Subject: RE: Planning Consultation on: FP/248/20/PL

Application ref: FP/248/20/PL

Description: Revised details relevant to the sport pitch & changing facilities building (previously approved under Y/38/09/). This site also lies within the parish of Yapton & is in CIL Zone 4 (Zero Rated) as other development.

Location: Land north of Felpham

date: April 2021
scale: 1:250@A1
drawing no: BDWS23254 11 Sheet 2
drawn: JM checked: DKM

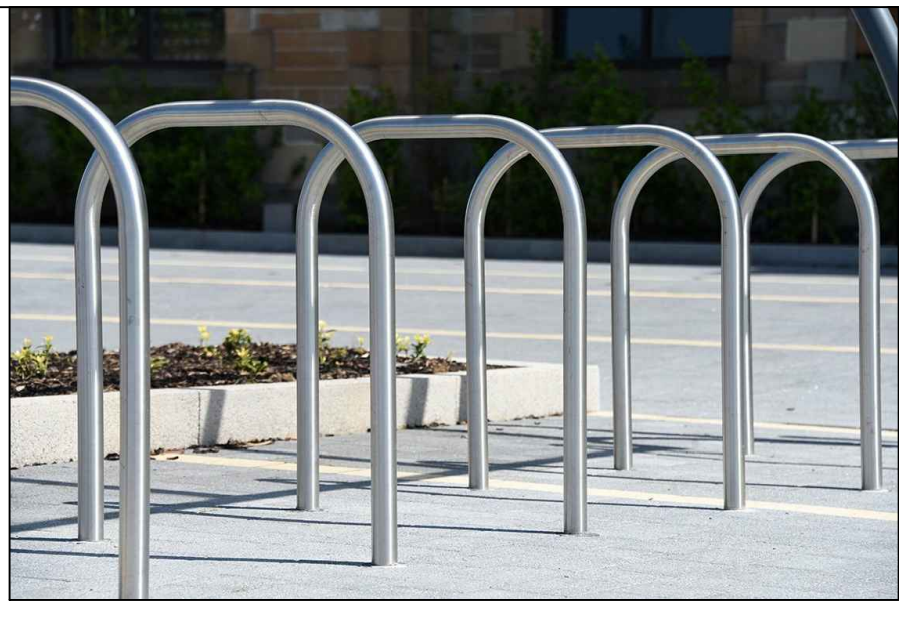
This response relates directly to the hard and soft landscape details as proposed within Dwgs Hard and Soft Landscape Proposals BDW S2354-11 Sheets 1 and 2 plus Changing Facility Zone E Stanhorn Grove Felpham April 2021 Soft Landscape Specification and Changing Facility Zone E Stanhorn Grove Felpham Landscape Management Plan 08/04/21. This response does not cover any amendment to site layout or facilities specification.

The information contained in the above documentation details suitable landscape proposals, proposing a scheme which would be fit for location with species type, quantities, planting densities and size at time of planting detailed in plan form. The hard landscaping, surfacing detail has also been detailed which is suitable for location.

Landscape provision as set out in Dwgs Hard and Soft Landscape Proposals BDW S2354-11 Sheets 1 and 2 April 2021.
